**Rezoning Transportation Analysis**  
**Petition Number: Insert Zoning Petition #2021-213**  
*General Location Identifier: 22706130*

Revision Log:	Date	Revision Log:
	01/21/2022	First Review (WB)
	02/21/2022	Second Review (WB)
	04/19/2022	Third Review (WB)
	05/25/2022	Fourth Review (WB)

Drawing file: revised-site-plans / 2021_213_revsiteplan_2022_02_15.pdf

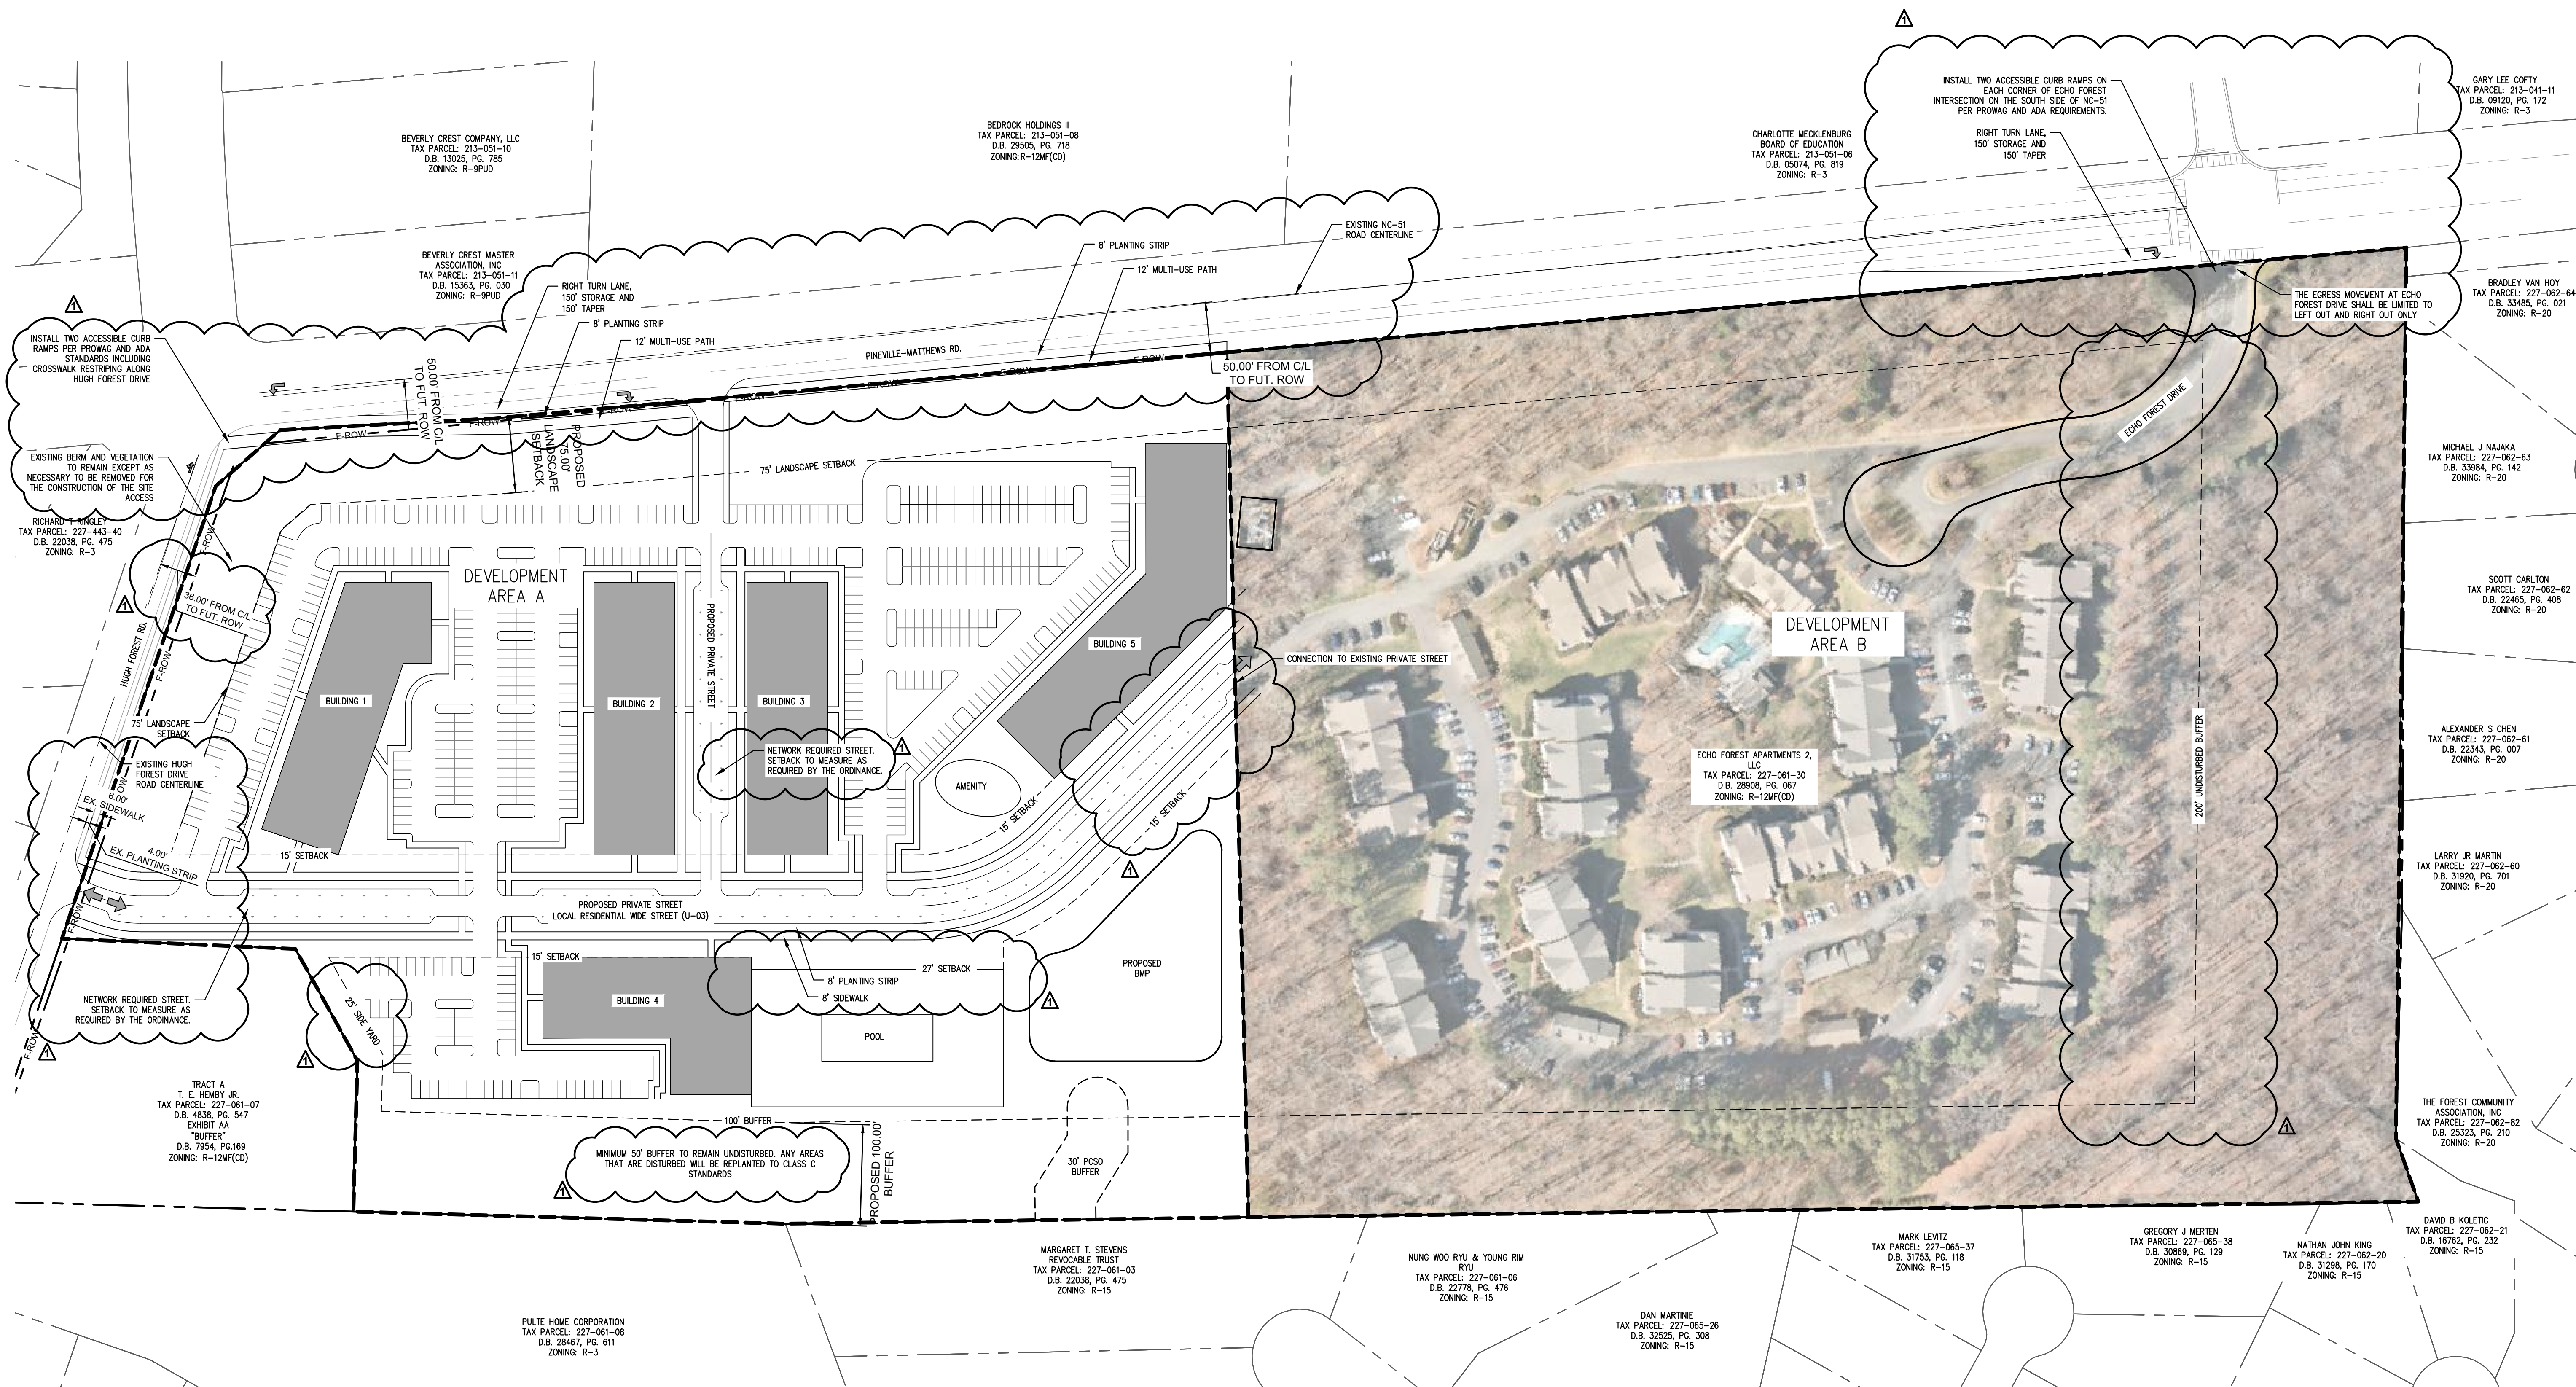
5. **Comment Clarification (Site plan reviewed on 2/21/22):** Site plan and conditional notes revisions are needed to commit to construct bicycle facilities by installing a 12-foot multi-use path along the site's entire Pineville-Matthews Road frontage in accordance with the Charlotte BIKES Policy. The site's frontage includes both Area's A and B.

12. **New Comment** (added on 5/24/22 to address sight distance concerns at Hugh Forest): Petitioner to ensure that the City's 50 x 50 and NCDOT's 10 x 70 Sight triangles are preserved site-side at the Hugh Forest Road intersection. No object that impedes sight distance between a height of 30 and 72 inches above the ground surface, including landscape mounds, shall be located within any of these sight triangles. Site plan revisions are needed to include the sight triangles.

13. **New Comment** (added on 5/24/22 to address traffic concerns along Hugh Forest): Revise site plan and conditional notes to commit to restriping the south leg of the Hugh Forest Road intersection to maximize turn lane storage on Hugh Forest Road.

16. **New Comment** (based on site plan reviewed on 2/21/22):  
Correct Conditional Transportation Note 3.i to dedicate 50-foot of right-of-way to NCDOT.
